Site Address:  
8 Naze Road,  
New Church,  
Rossendale,  
BB4 9EF

Old Application Number: 2020/0612

Following the refusal of a previous scheme at the above site a list of issues were sent via email to address for any future applications. This letter highlights the list (below) and following each point there is an explanation to how they have been reviewed and updated on the drawings which accompany this submission.

01 Proposed Front Elevation
Scale 1:50

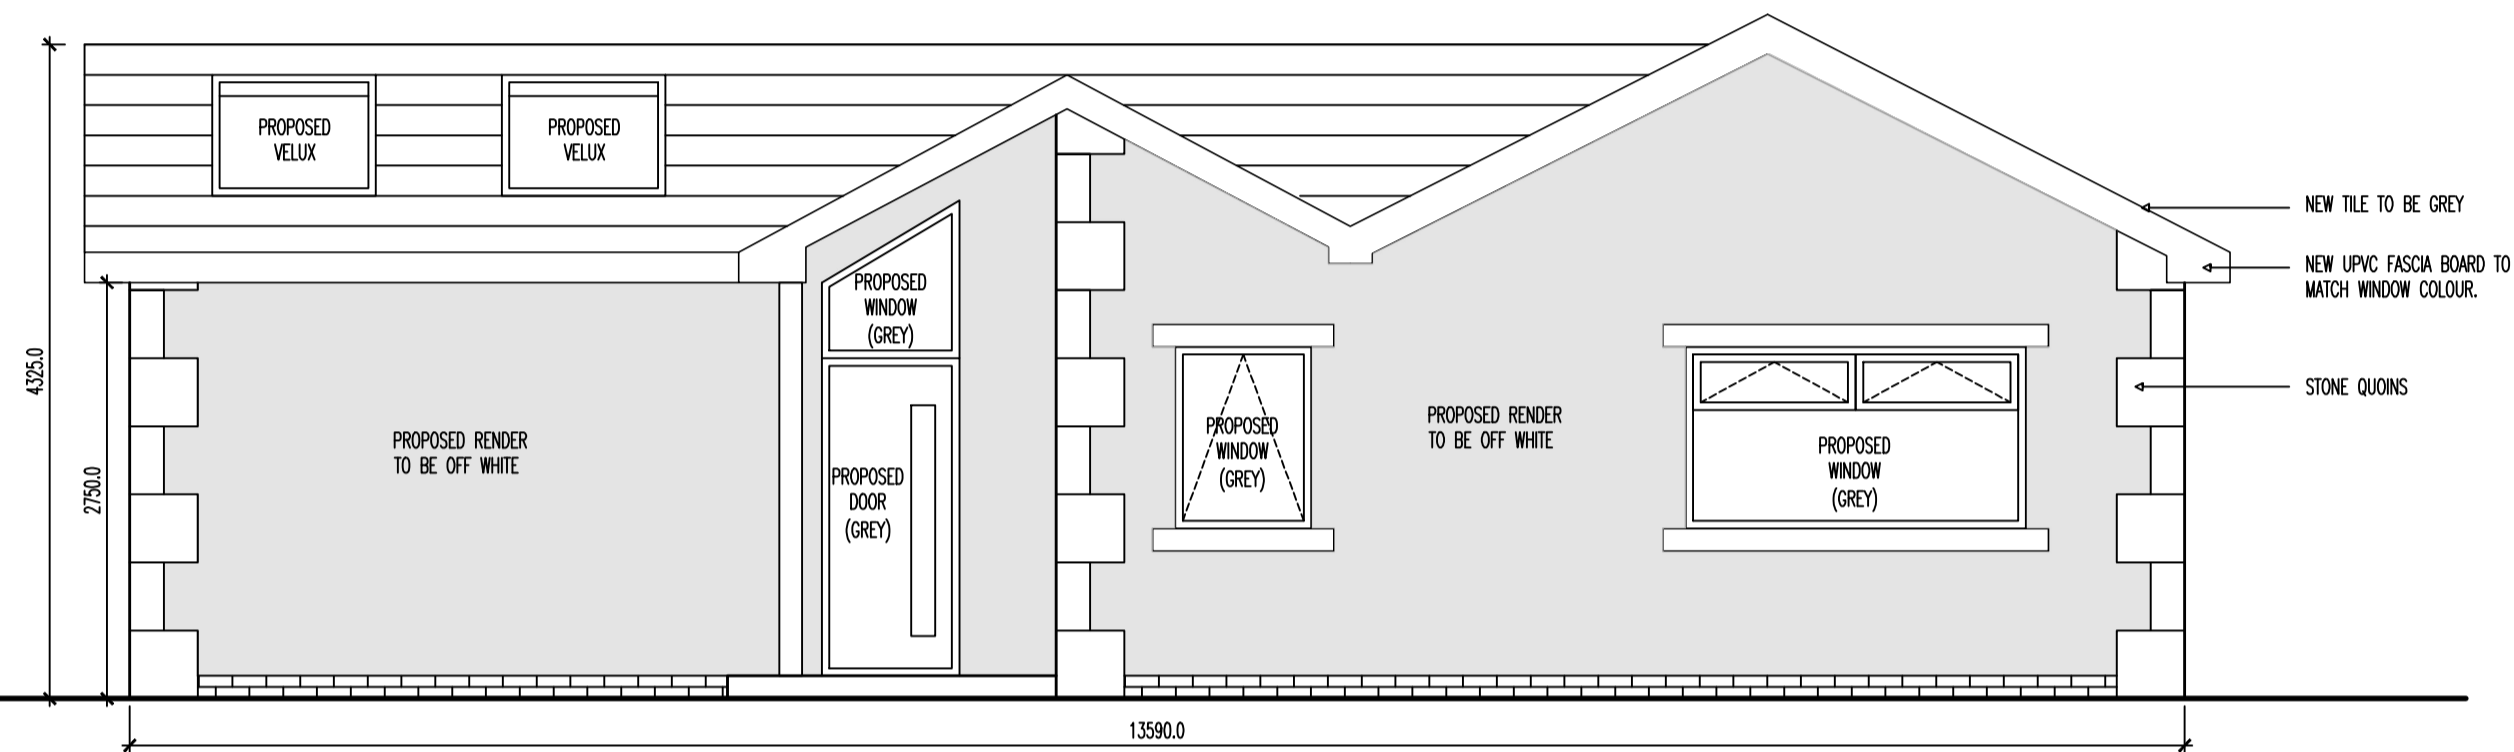
3. Parking spaces should not be immediately in front of windows serving habitable rooms and a clearway to the principal doors should be retained.

*Submission response: Window on principle elevation removed as room has more than adequate light. Main door has a roof overhang with a post as such no car will be able to block the route.*

01 Proposed Ground Floor Plan  
Scale 1:50

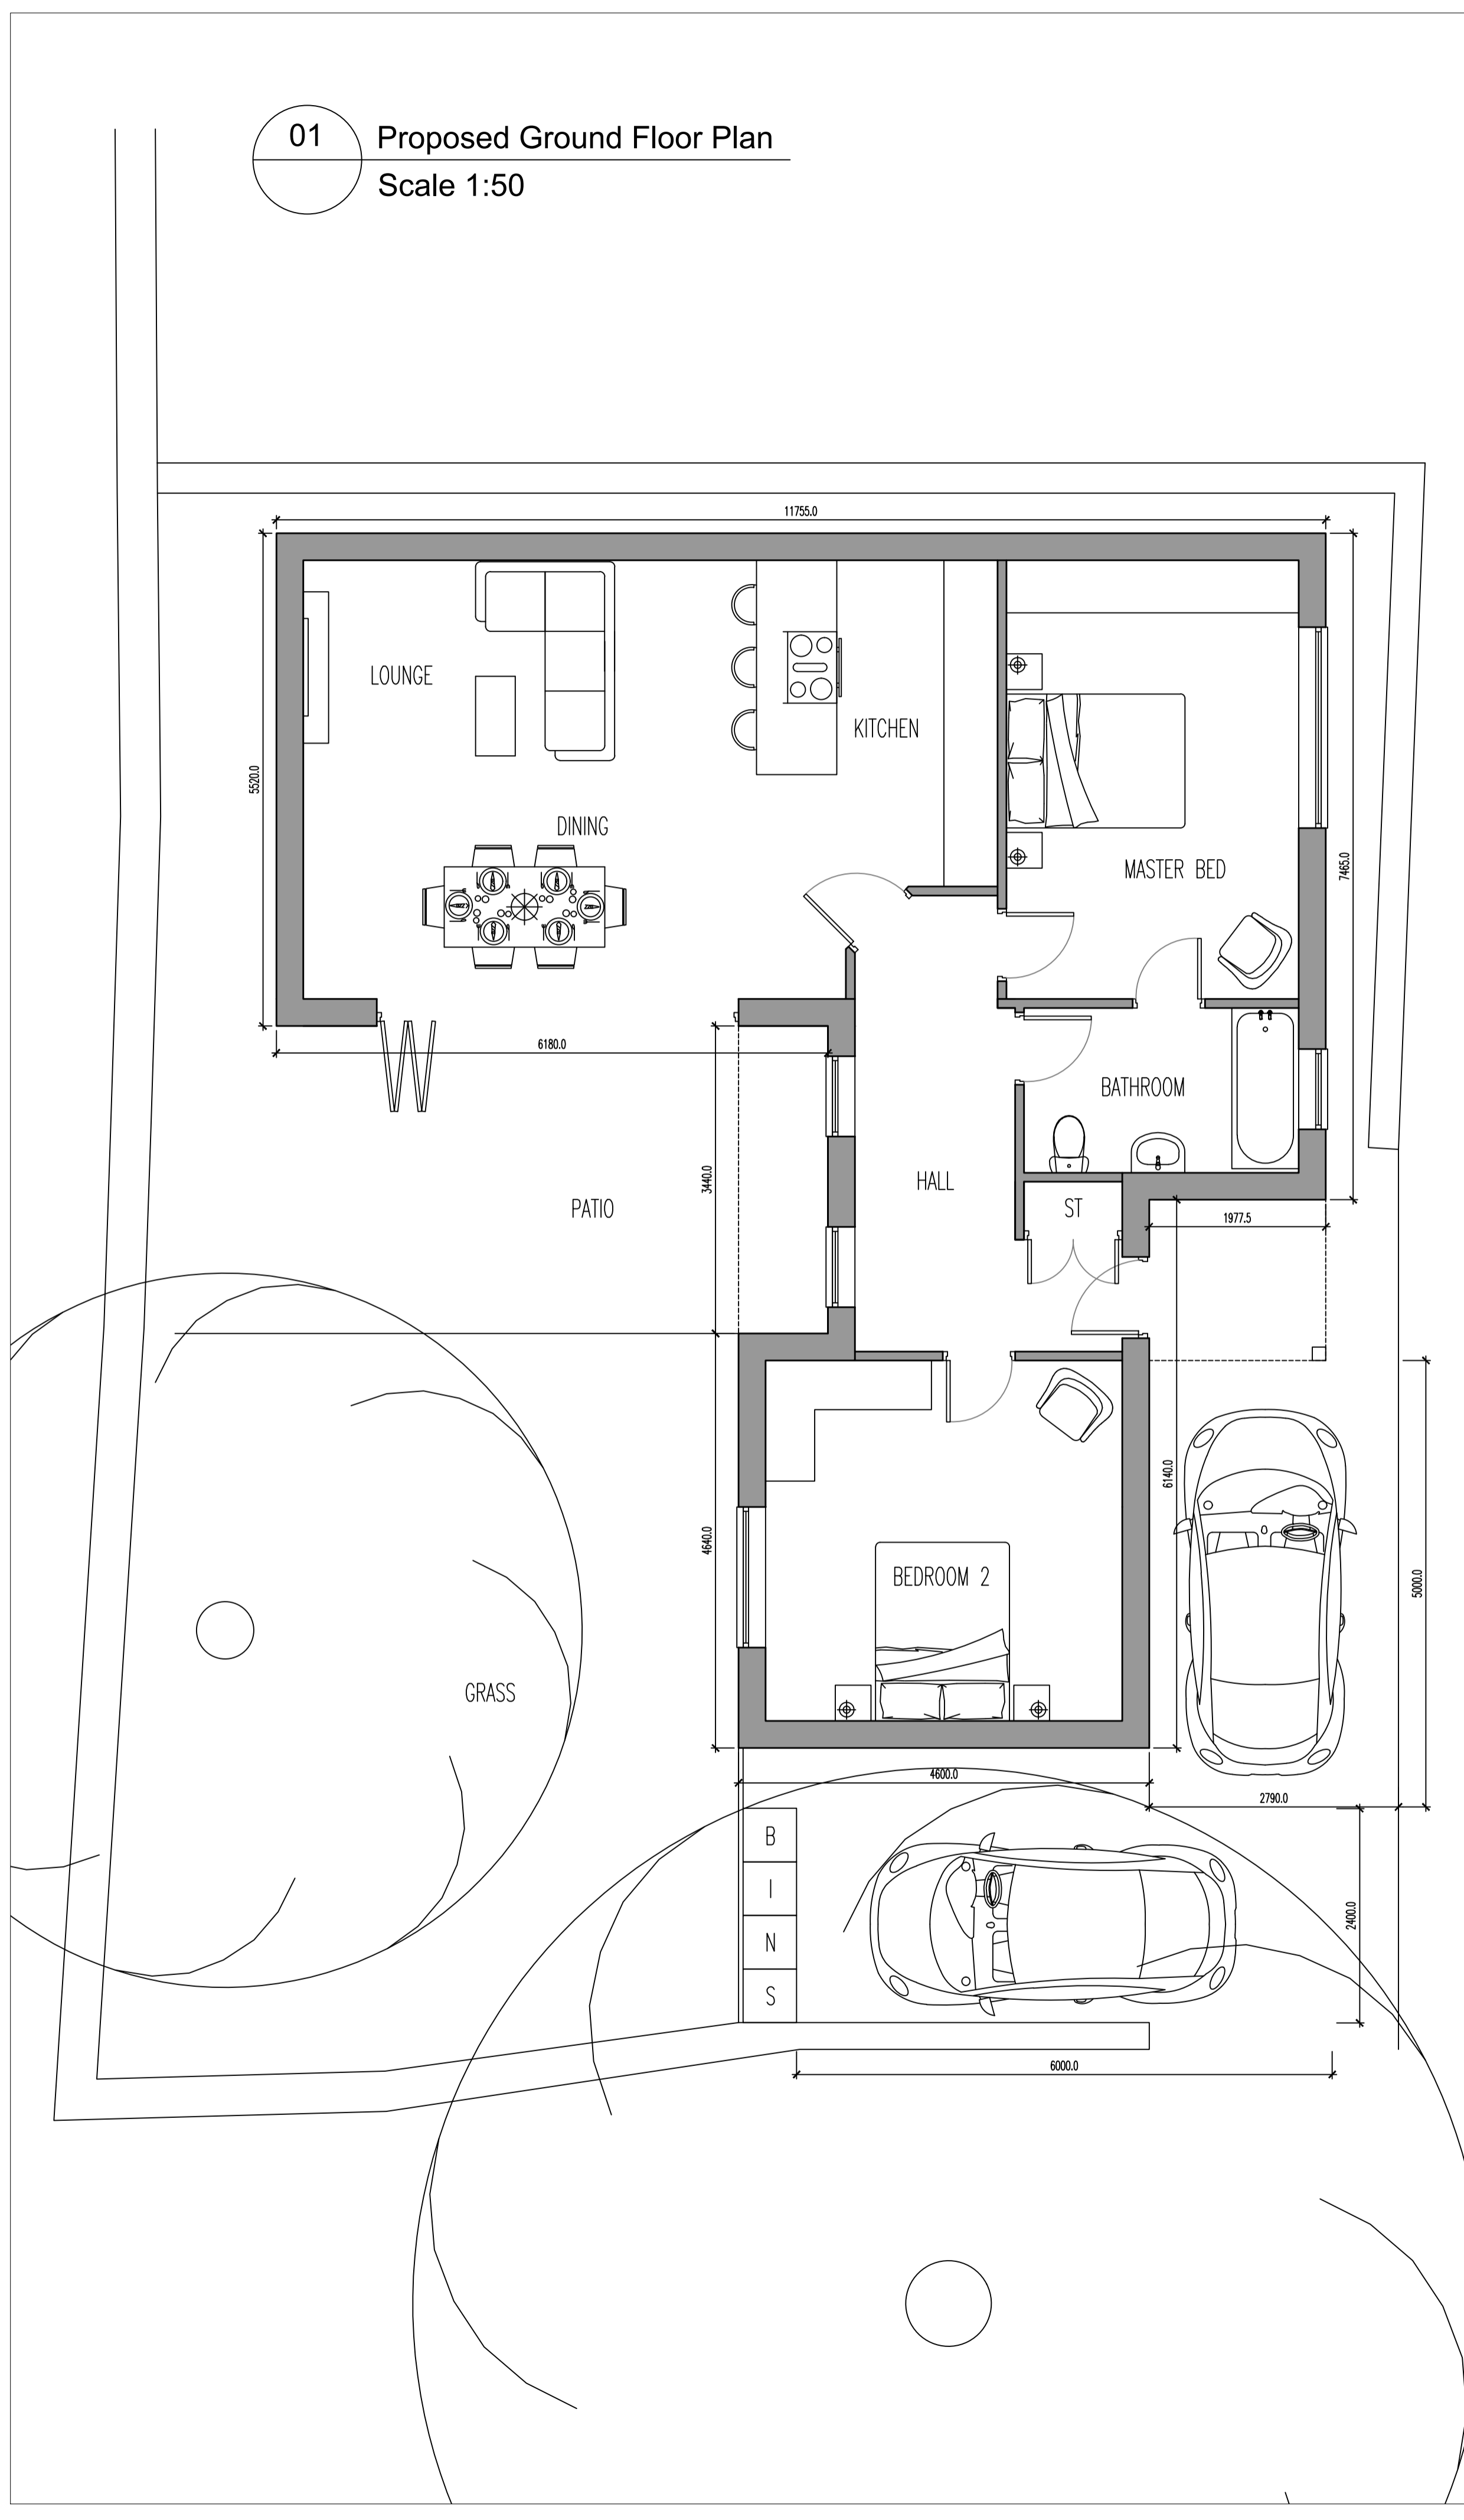
1. Cramped development extending to boundary of the site on two sides and within 0.6m of a retaining wall and 2.1m on the other side.

2. Parking spaces should be a minimum width of 2.4m and at least one of the two per dwelling should be 6m in length and the other should be a minimum of 4.8m. Bin storage should not be within the area allocated for parking.

4. It is advised that turning circles are shown to demonstrate that it will not be necessary for vehicles to reverse onto Turnpike.

8. Indicate that access to the rear garden of 1 The Coach house will be retained.

*Submission response: Development has been reduced to 1.4m away from neighbouring boundary and as such has reduced the cramped feel to the site*

*Submission response: Parking bays have been dimensioned and shown to be 2.4 x 4.8/6m as requested. Property has been reduced next to the bin store to leave adequate room to service the bins.*

*Submission response: Turning circles added to drawings as requested.*

*Submission response: Note added to drawings to indicate that access will be retained.*

01 Proposed Topographical Section
Scale 1:50

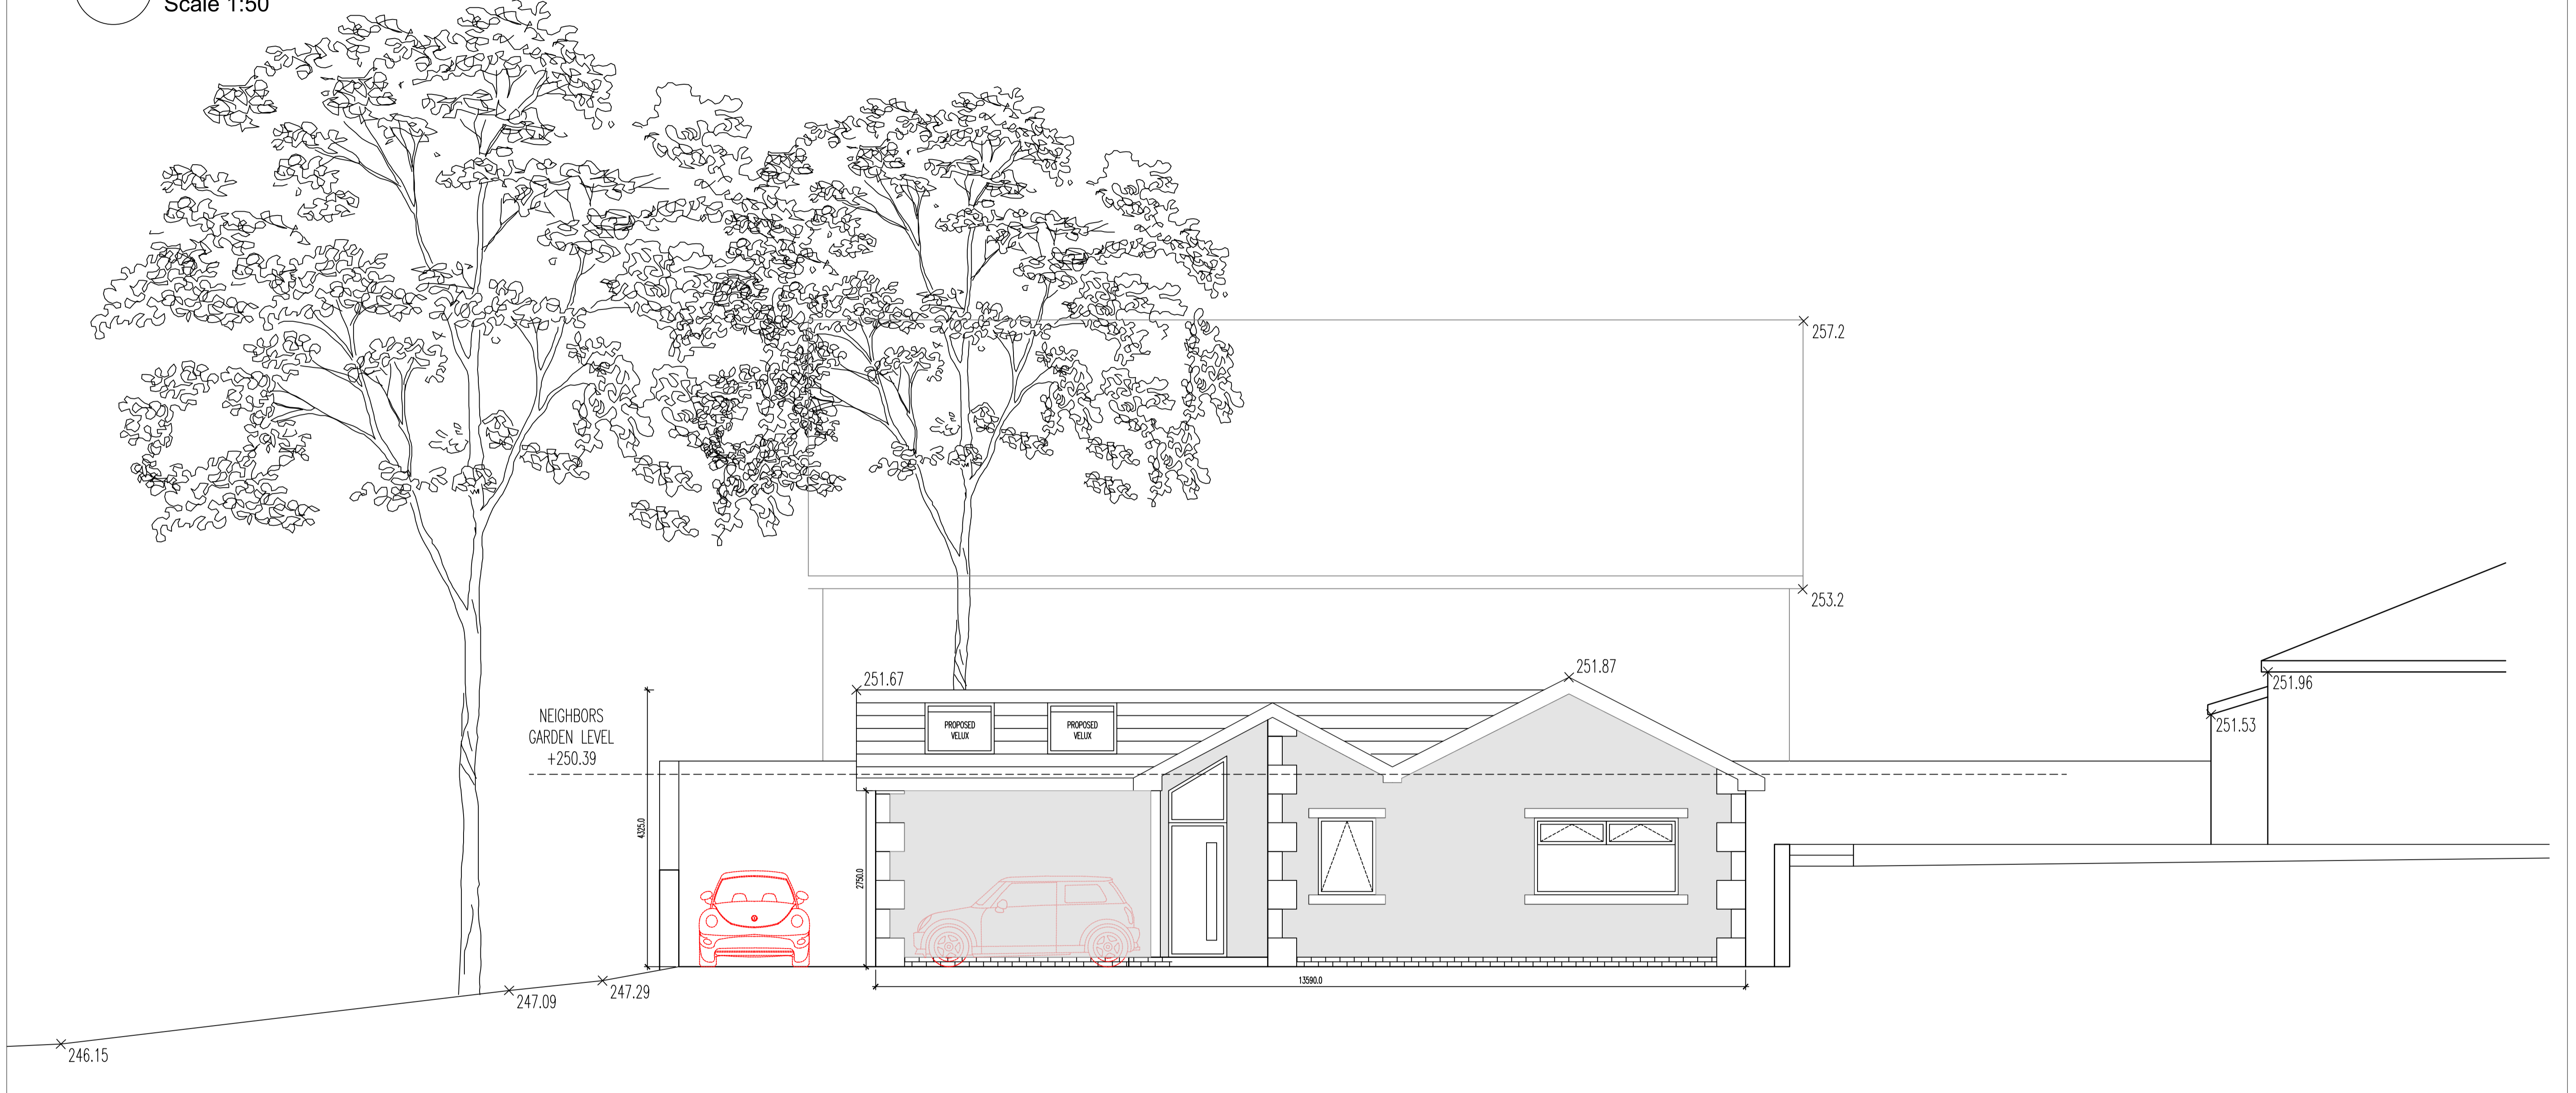
7. Windows should have a satisfactory level of outlook and not look directly and at close proximity onto a retaining wall.

*Submission response: Retaining wall has been lowered to achieve satisfactory outlook.*
